**St Francis College Stage 1 - Landscaping (SSD-10365)
Request for Additional Information**

I refer to the EIS and RtS submitted for the St Francis College Stage 1 (Landscaping) State significant development application (SSD-10365). After careful consideration, the Department is requesting that you provide additional information to clarify the quantity and size of plantings proposed as part of the development.

04 TREE PLANTING 75-100L  
SCALE 1:20

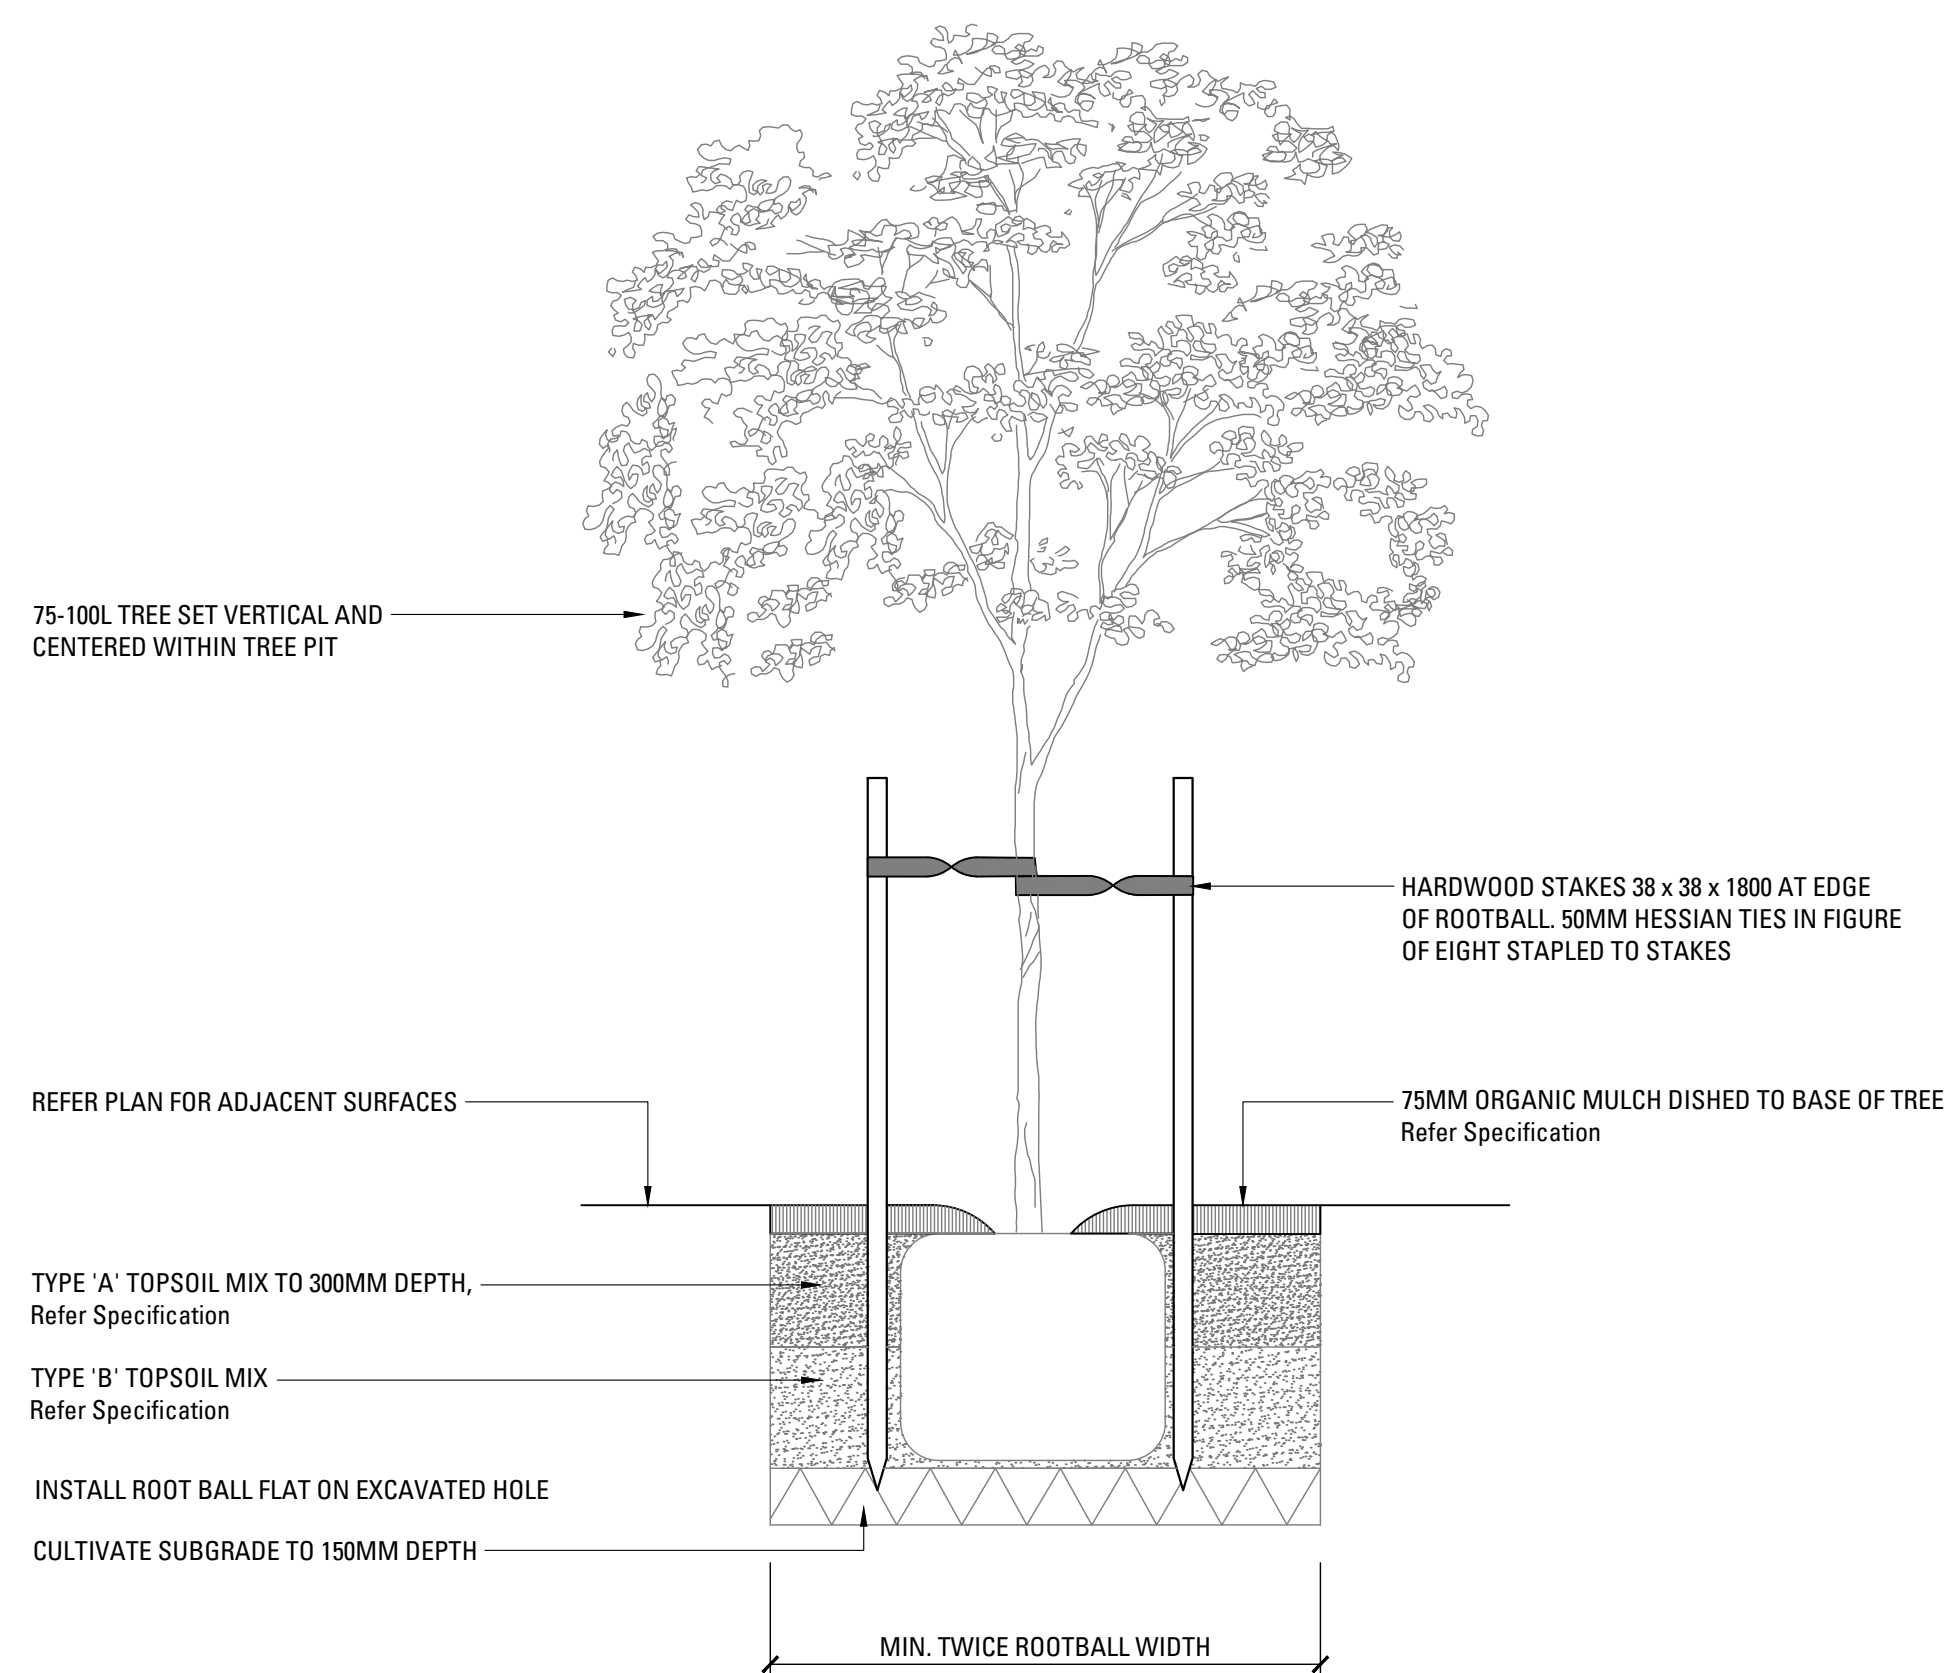
The submitted EIS advises that the proposed plant schedule includes 14 *Lophostermon confertus* (Brush Box) trees, and that each of the trees planted would have a pot size of 100L. However, the Landscaping Plan Rev F prepared by Arcadia and dated 23 September 2020 advises that the plant schedule includes 28 Brush Box trees, and that each tree planted would have a pot size of 200L. The submitted RtS does not contain any information to clarify the inconsistencies. Please provide clarity and confirmation of the correct figures.
